Fire Marshal Division

RE: Marco's Pizza
80 Amarillo Lane
Sanford, N.C. 27332

Application Number: BCOM 1810-0002

1 LIFE SAFETY PLAN
 1/4" = 1'-0"

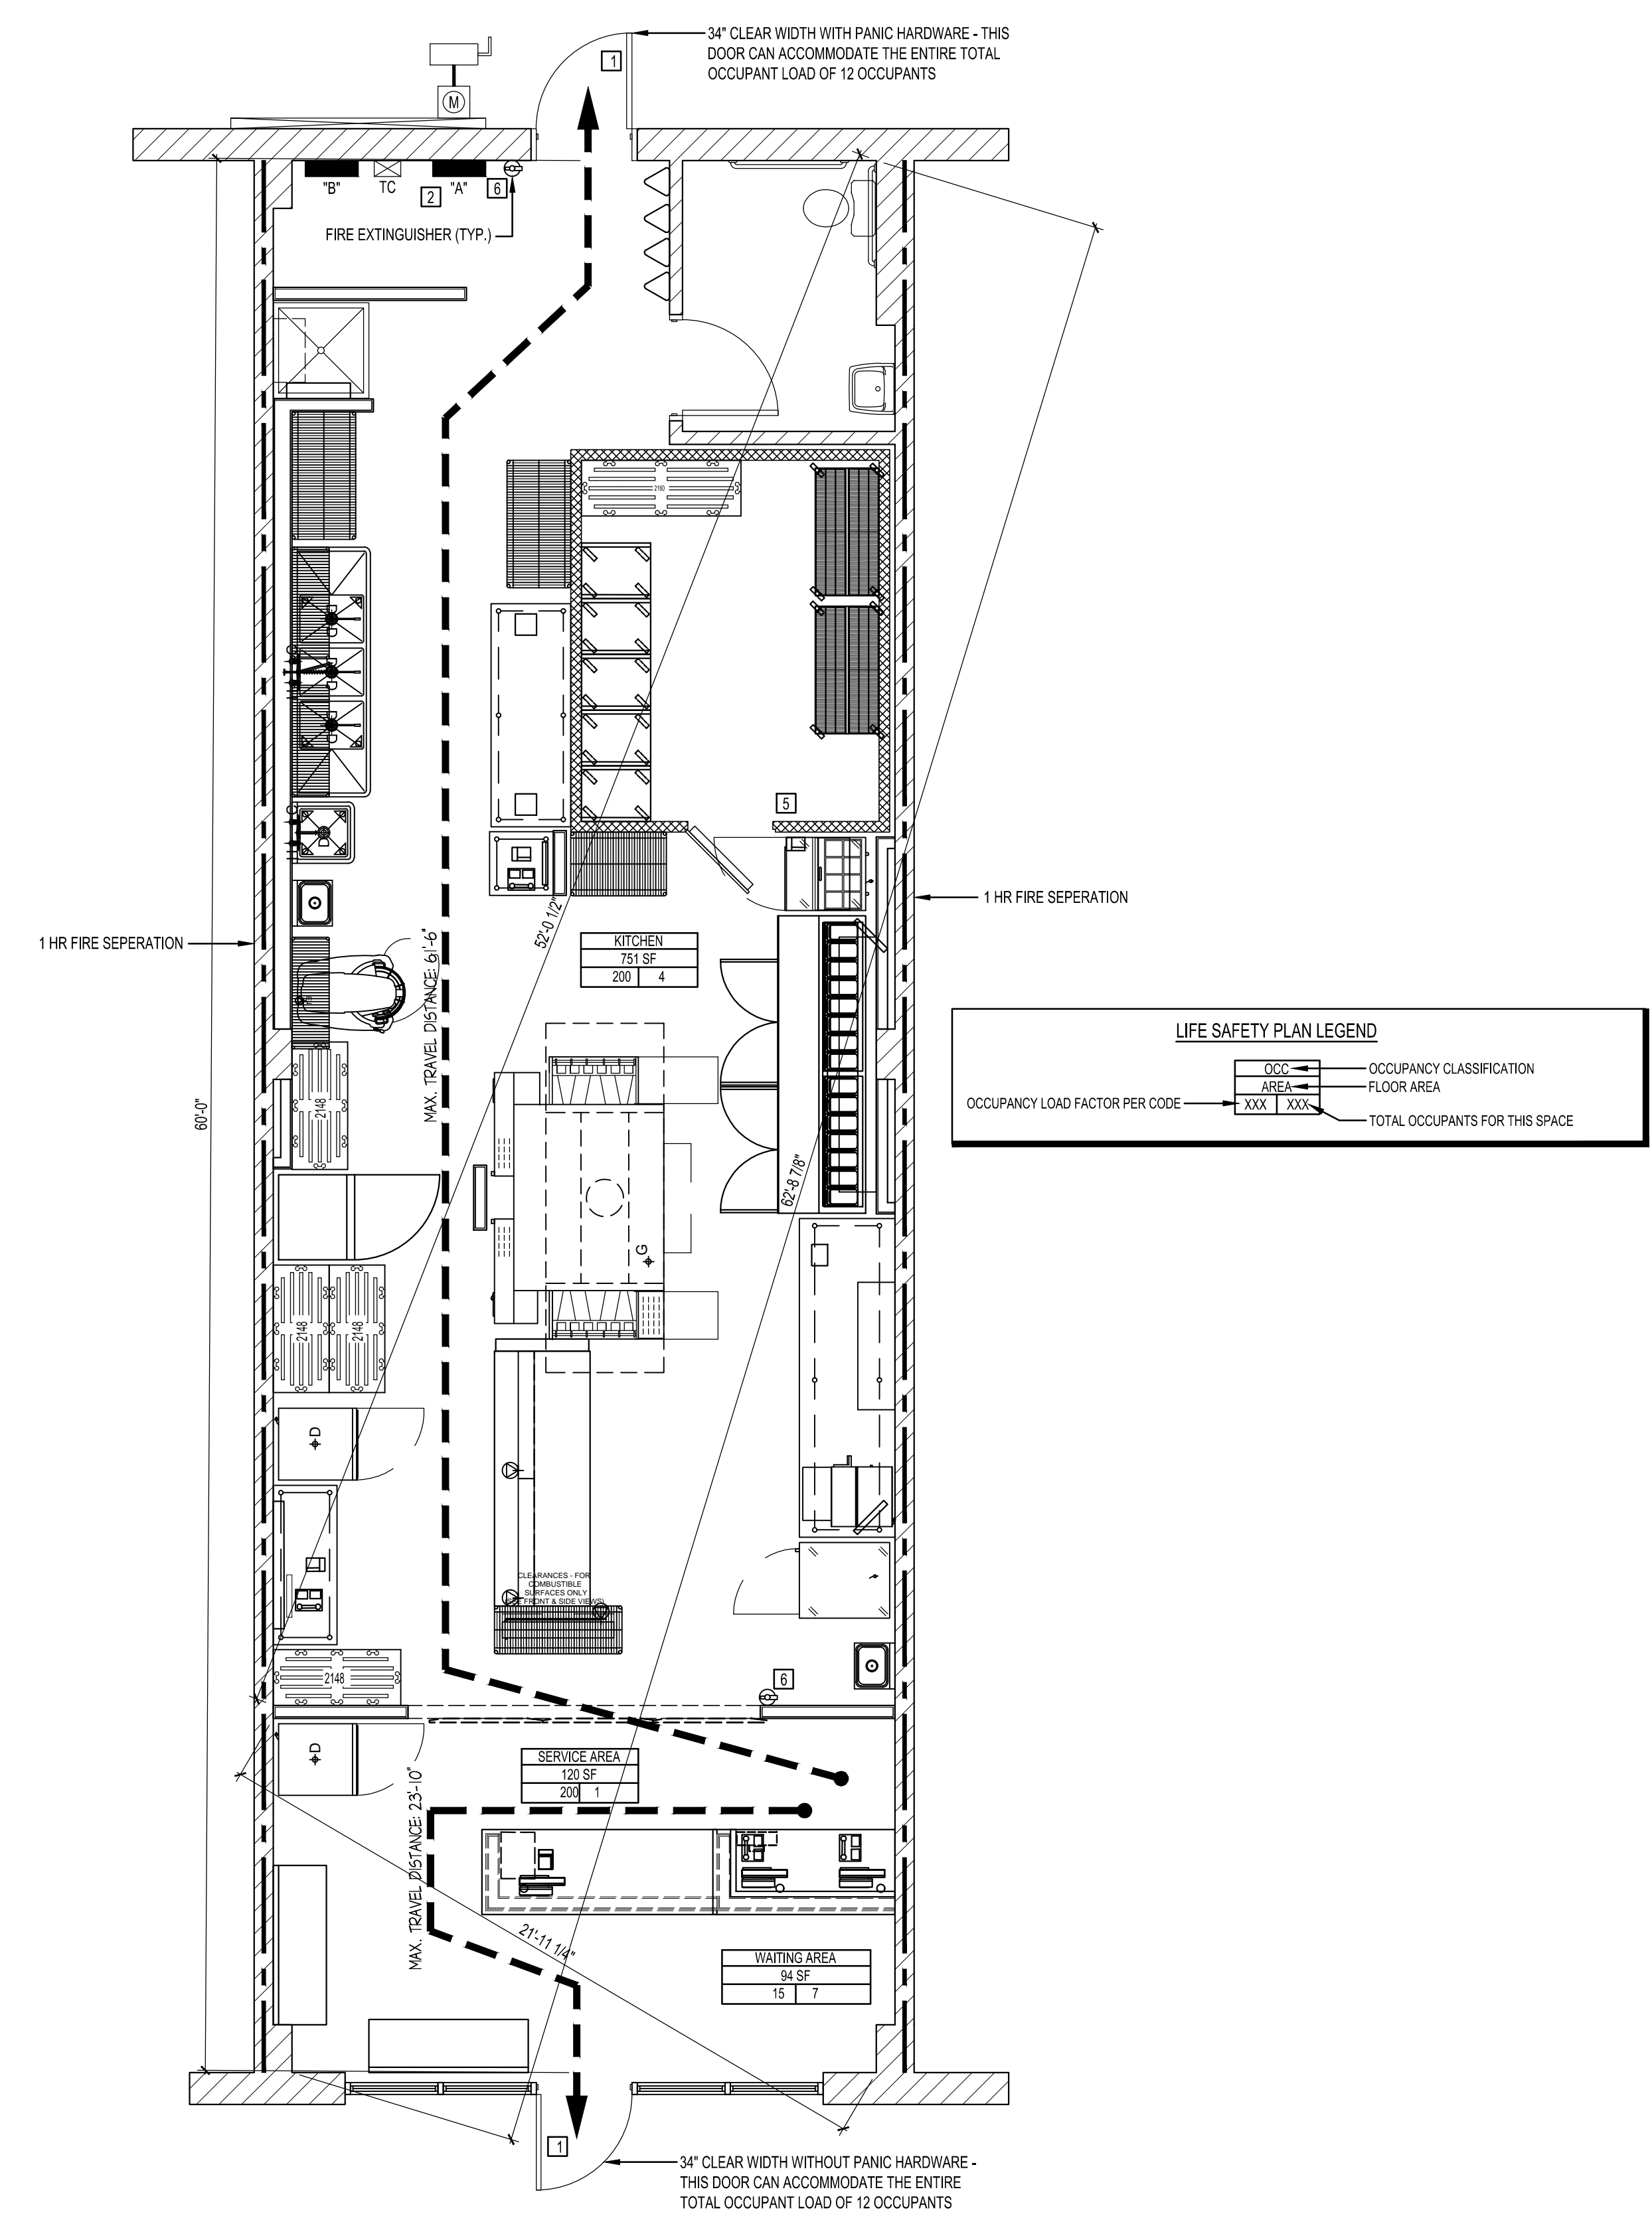
- **906.1 Fire Extinguishers**
 - Fire extinguishers shall be placed in approved locations, one in the area of the rear storage space and one in the front entrance area.
 - The fire extinguishers provided shall have a minimum rating of 2A 10B: C and shall not be installed higher than 5 feet above the finished floor.
 - In addition to the above extinguishers, a portable fire extinguisher shall be provided within a 30-foot (9144 mm) travel distance of commercial-type cooking equipment. Cooking equipment involving vegetable or animal oils and fats shall be protected by a Class K rated portable extinguisher.

DOOR TYPES

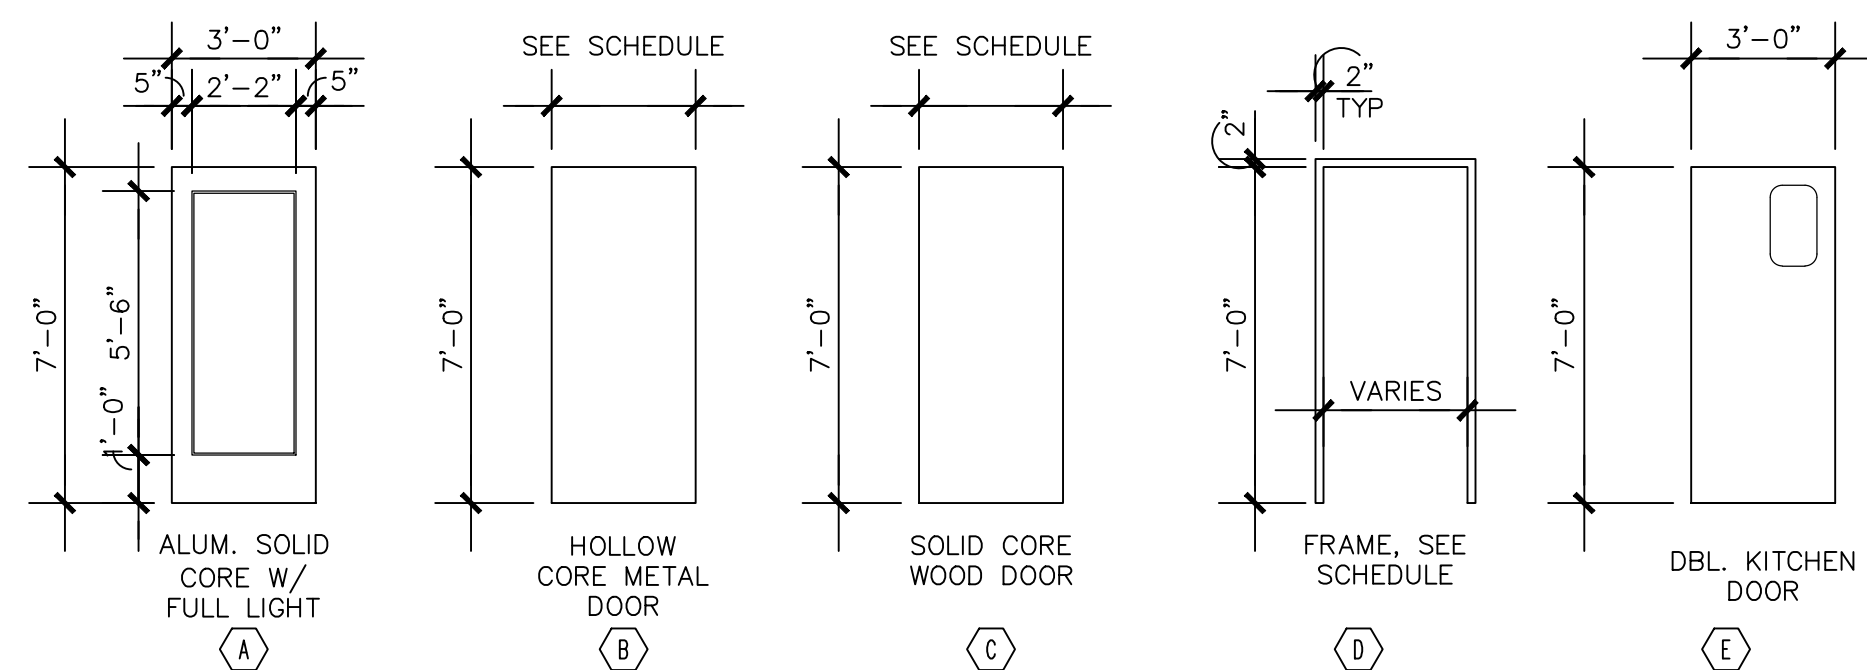
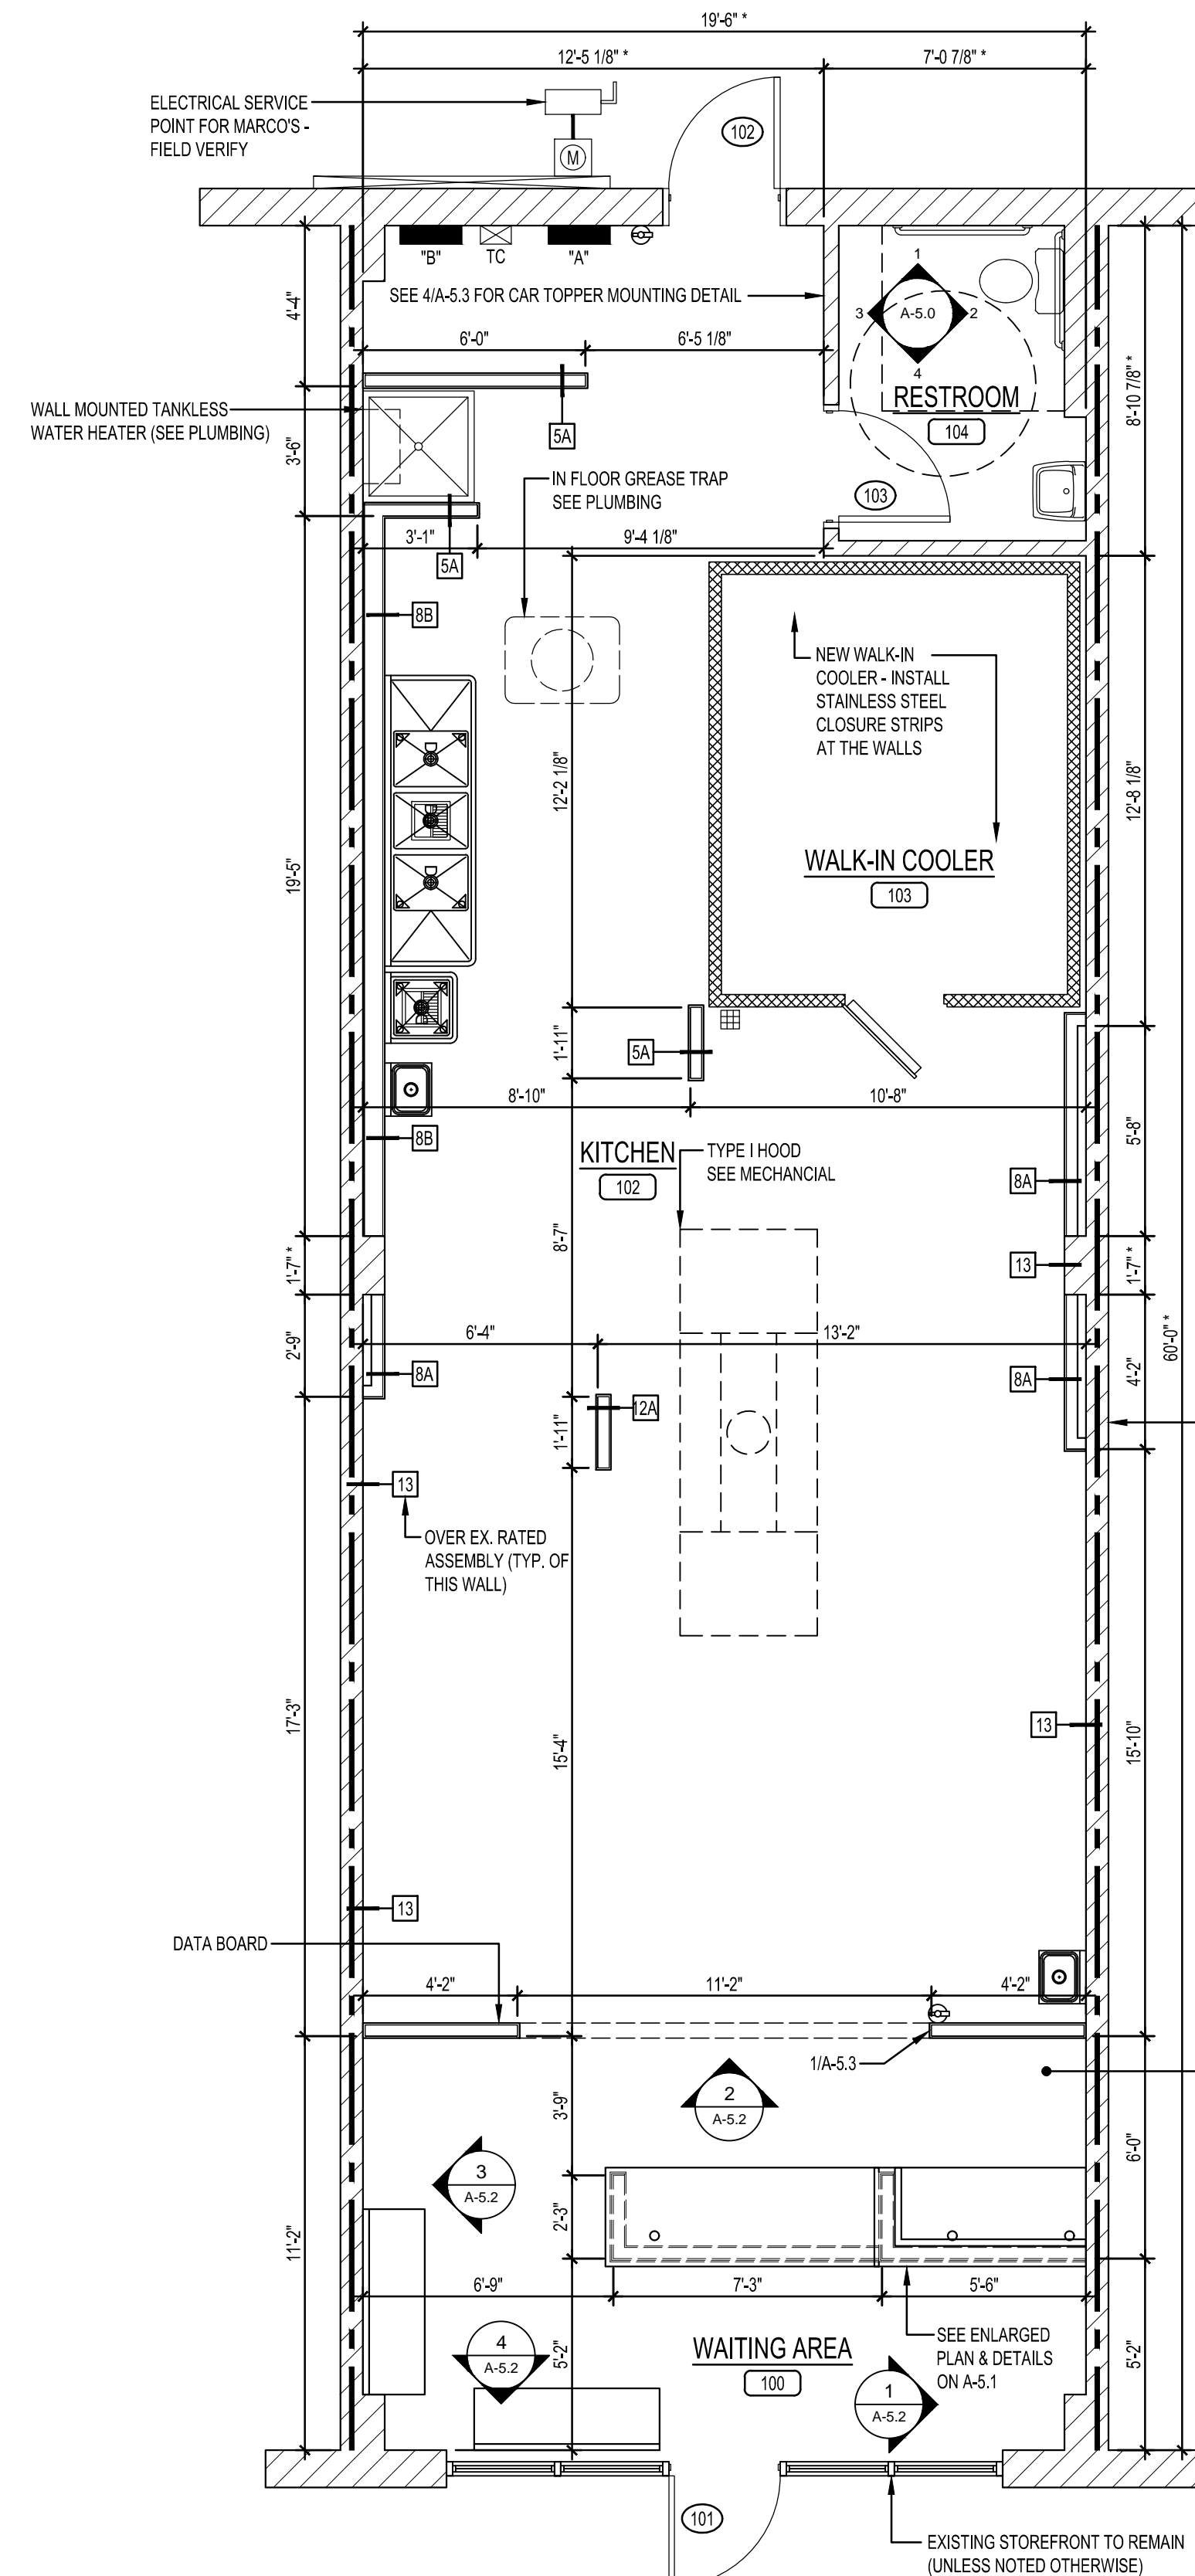
- **Panic Hardware**
 - UL 305 listed panic hardware is required on exit doors serving a room/space with an occupant load >50, also indicated on Building code summary. Panic hardware is not included on door schedule sheet B8 of Drawings.
